42 HONEYSUCKLE DRIVE COTTAGE CREEK PRECINCT NEWCASTLE

NEWCASTLE CITY COUNCIL
DEVELOPMENT APPLICATION

ARCHITECTURAL DESIGN RESPONSES

MAY 2018
REV B

11 AM Equinox

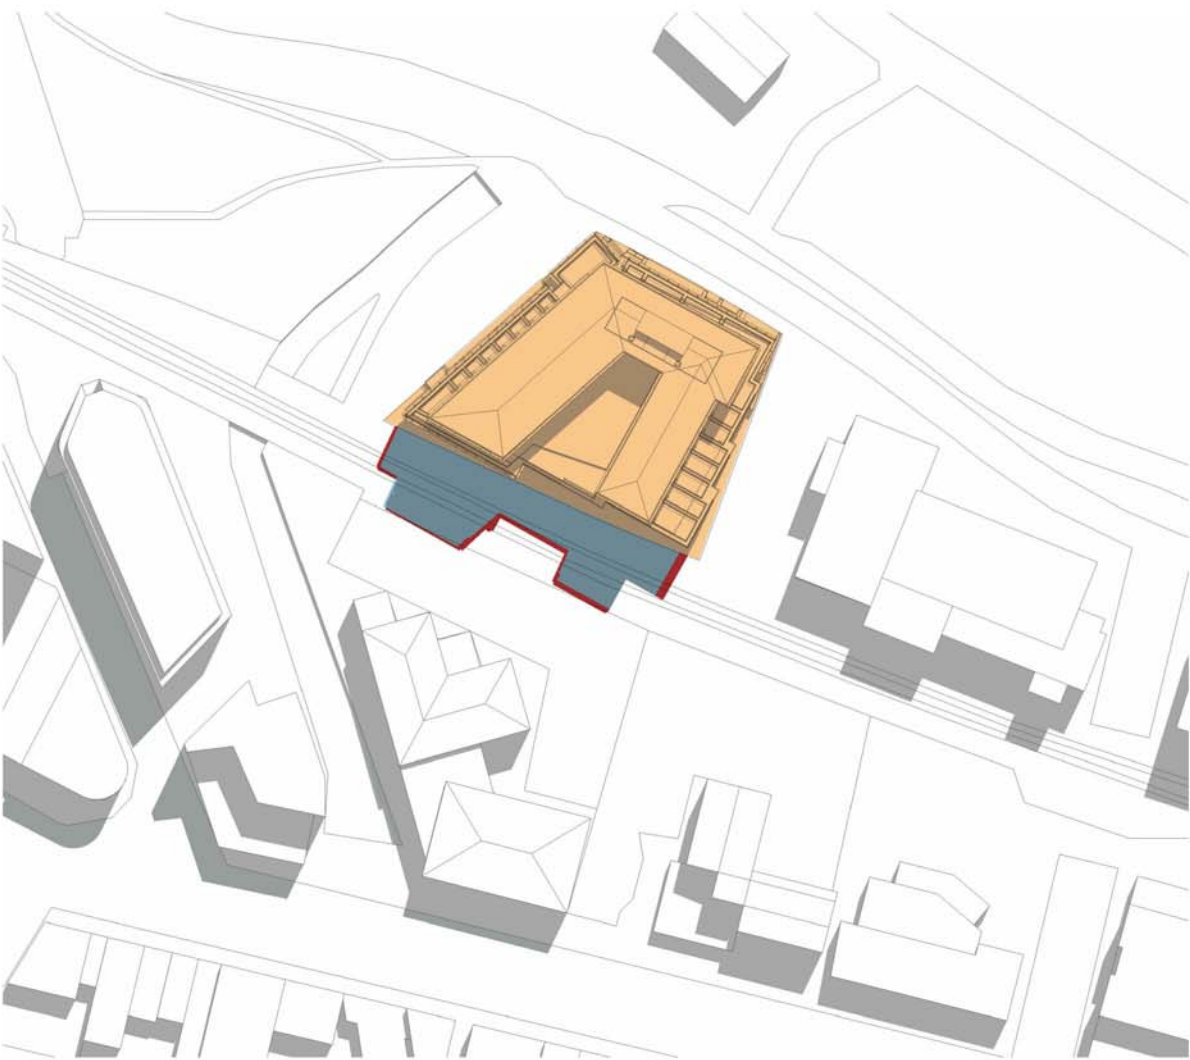
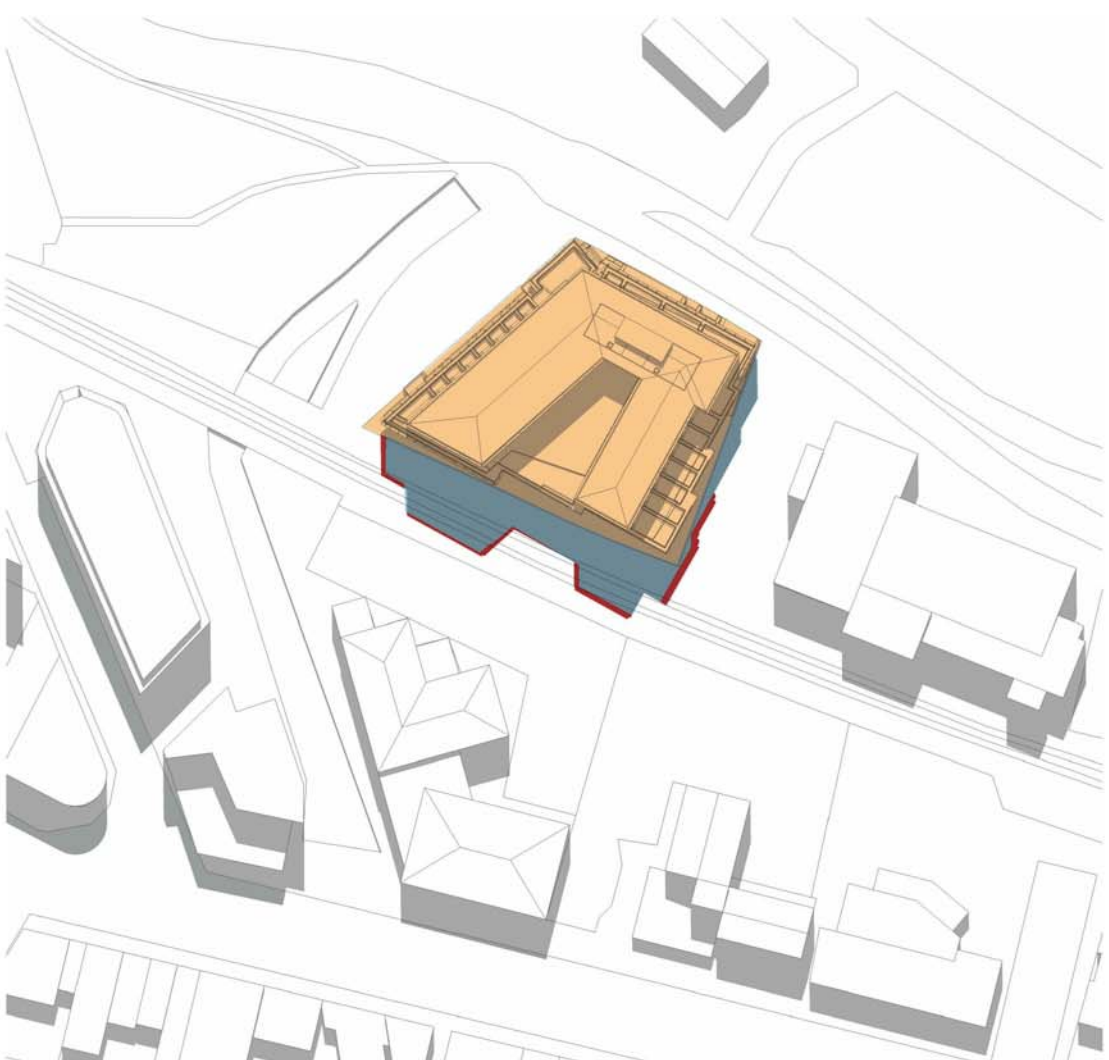
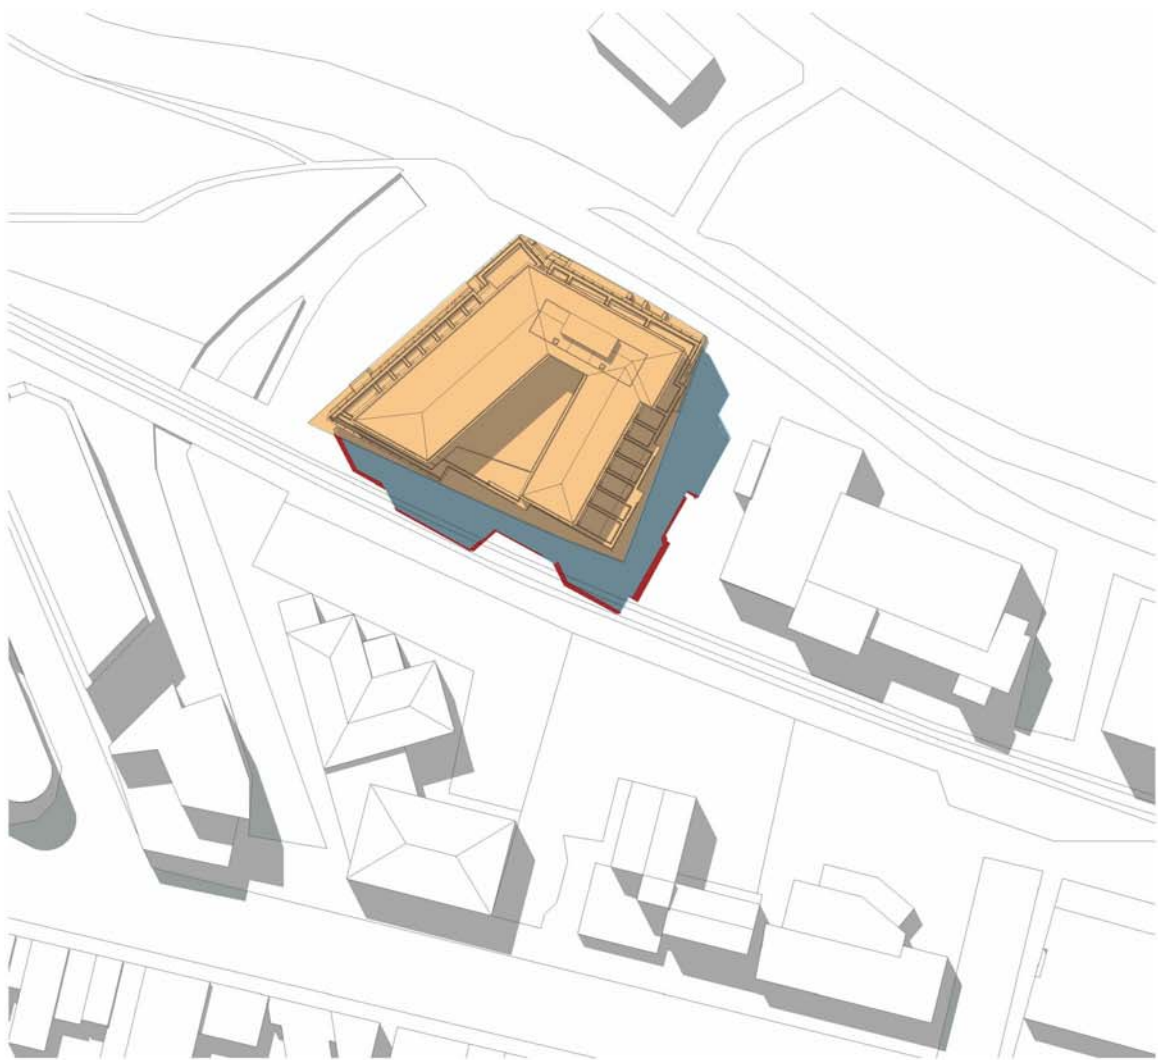
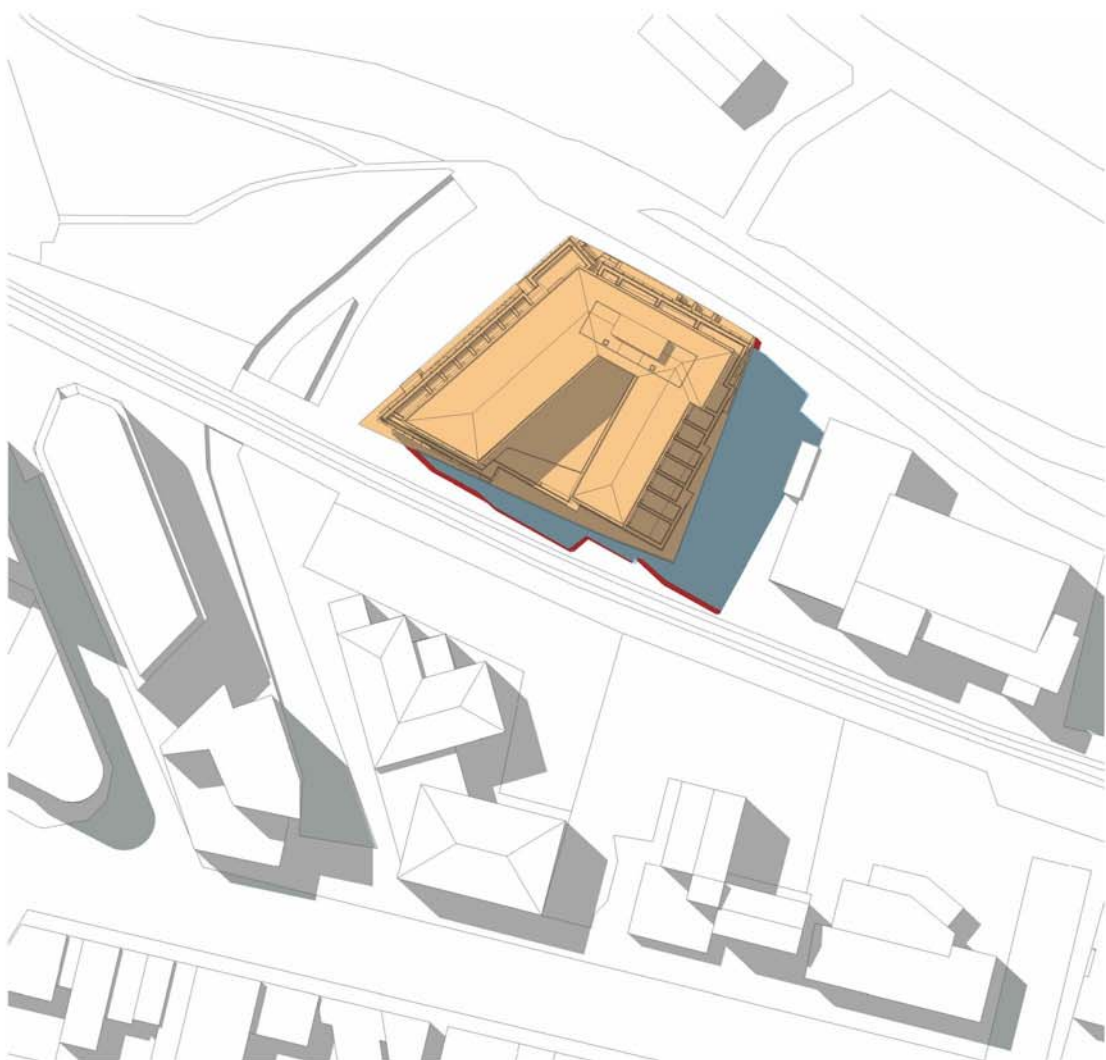
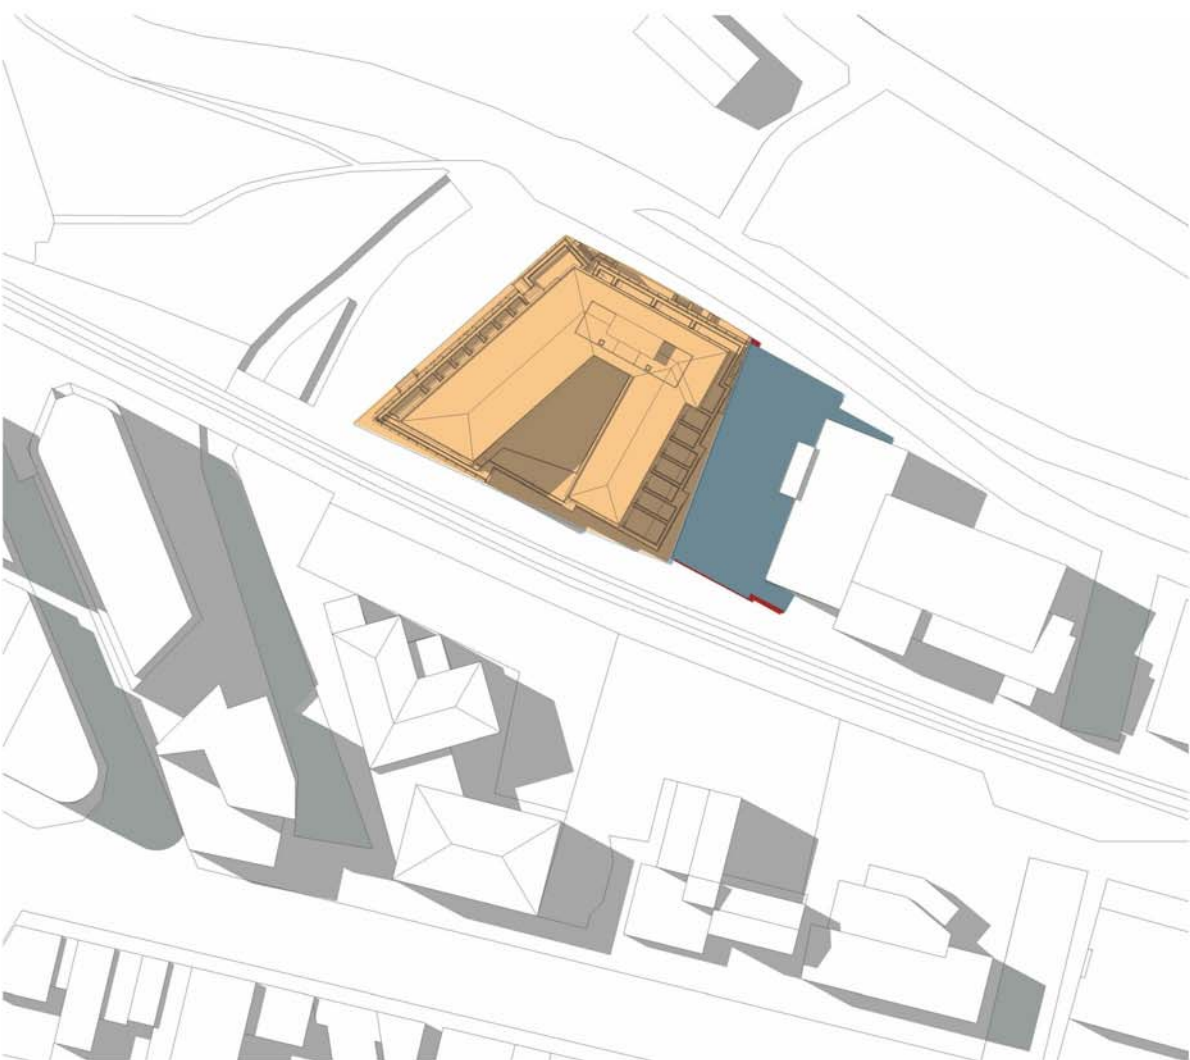
‘Provide revised overshadowing diagrams which clearly show a comparison between the proposed portions of the building which exceed the 30m height standard and a fully compliant building’

See the revised overshadowing diagrams illustrating the comparison between the 30m height standard and the current building form in both the winter solstice and the equinox.

It can be seen that the additional height has very little difference in the extended shadow due to the extra height being placed within the centre of the roof plan across the northern face. With varying permissible heights from neighbouring buildings ensures that the building maintains a presence and prominent address without affecting greatly the green belt and pedestrian connection from the light rail to the waterfront.

Section
Section East-West
1 : 150

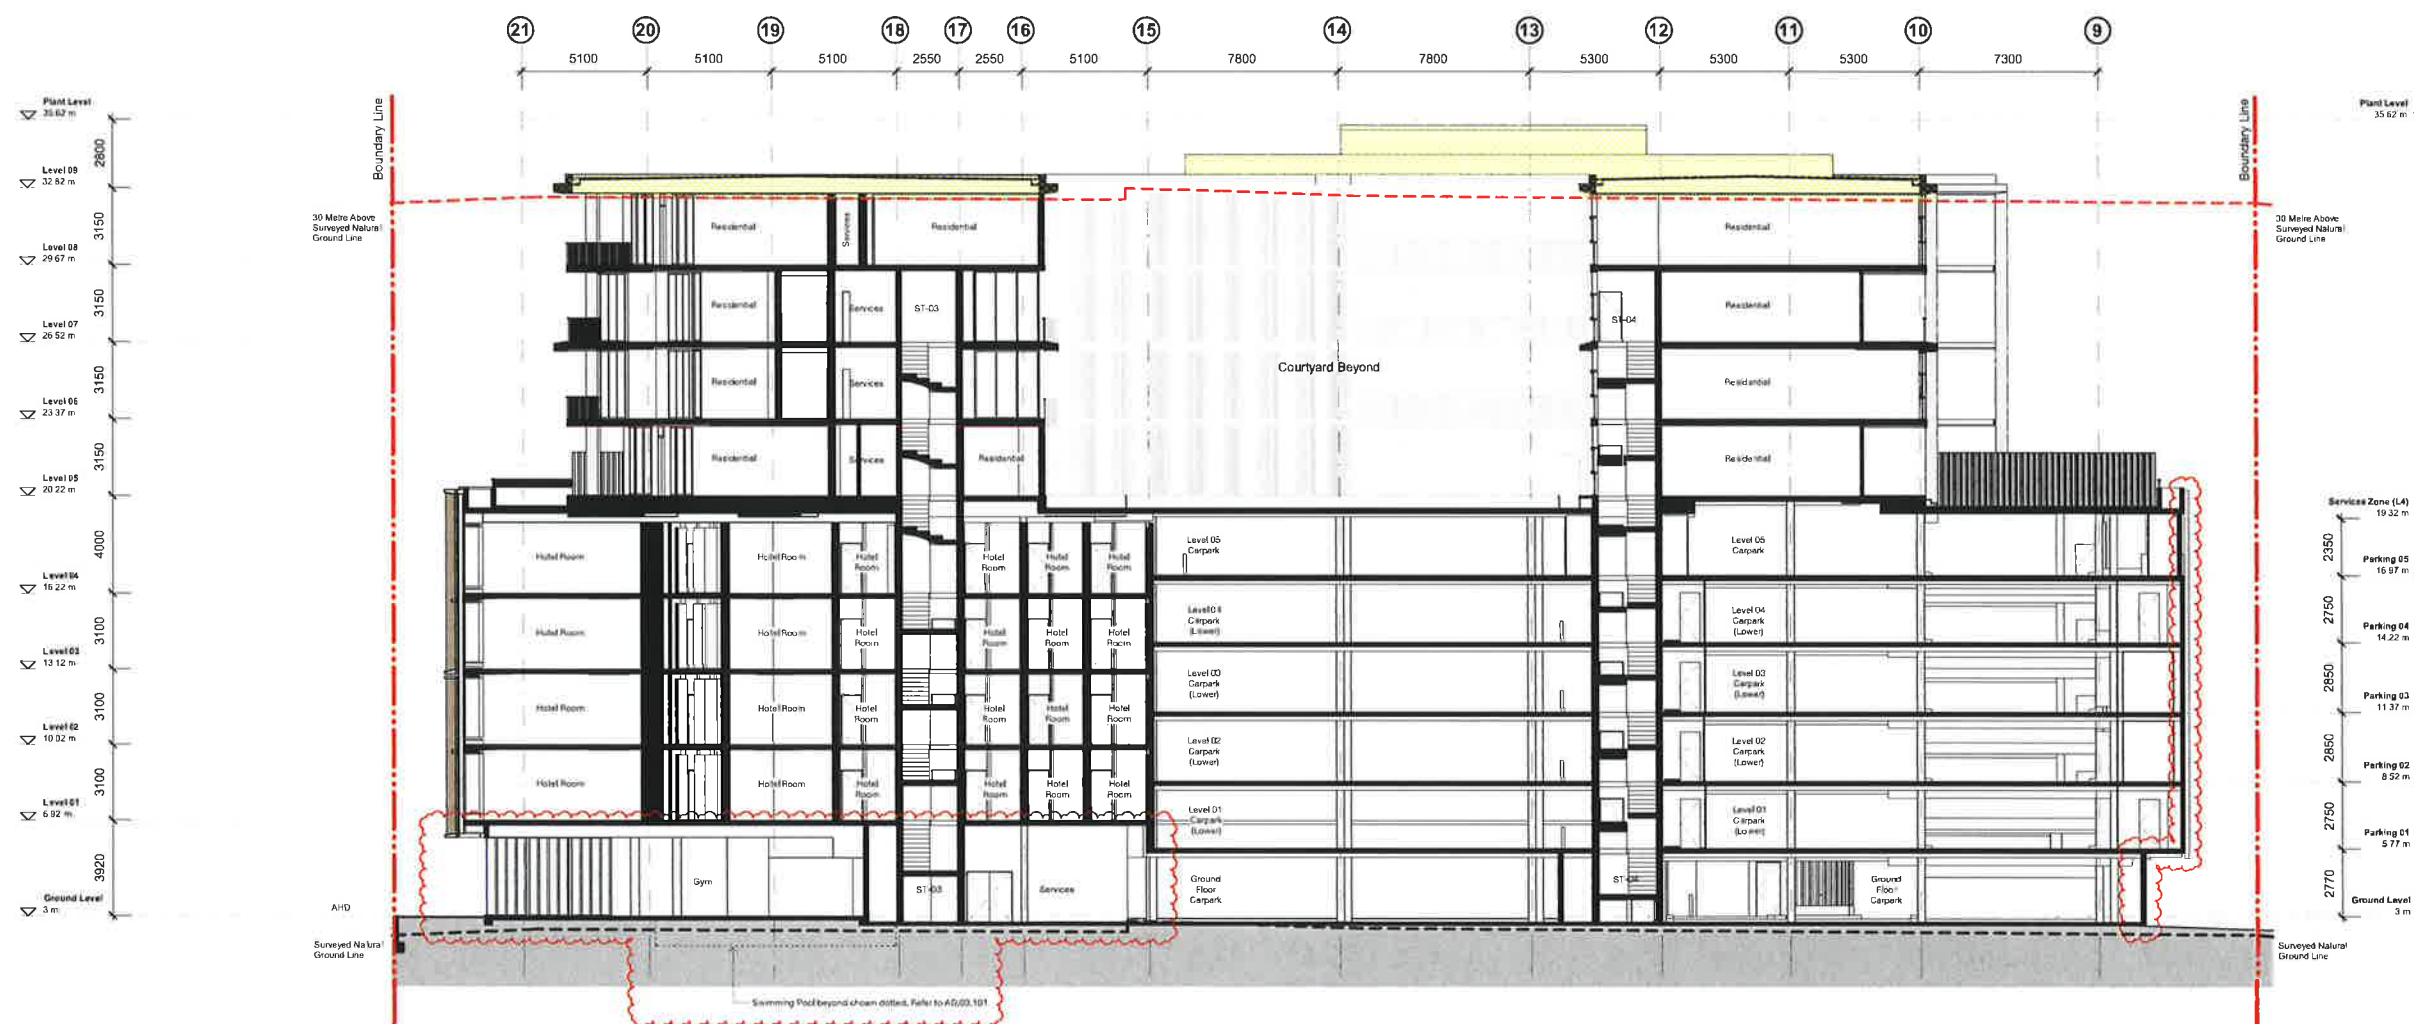
‘Provide further detail in plan and section form clearly identifying and quantifying the parts of the building which exceed the maximum height of 30 metres’

See plan, sections & 3D through the building illustrating the elements of the building that are beyond the maximum 30m height limit (highlighted in green). The red line demonstrates the 30m offset from the surveyed existing ground plane.

The green shading highlights clearly the portions of the building that are beyond the 30m height limit. These are the ends of the south roof to both east and west “wings” and the fire sprinkler tanks set in the middle of the plan to the northern roof.
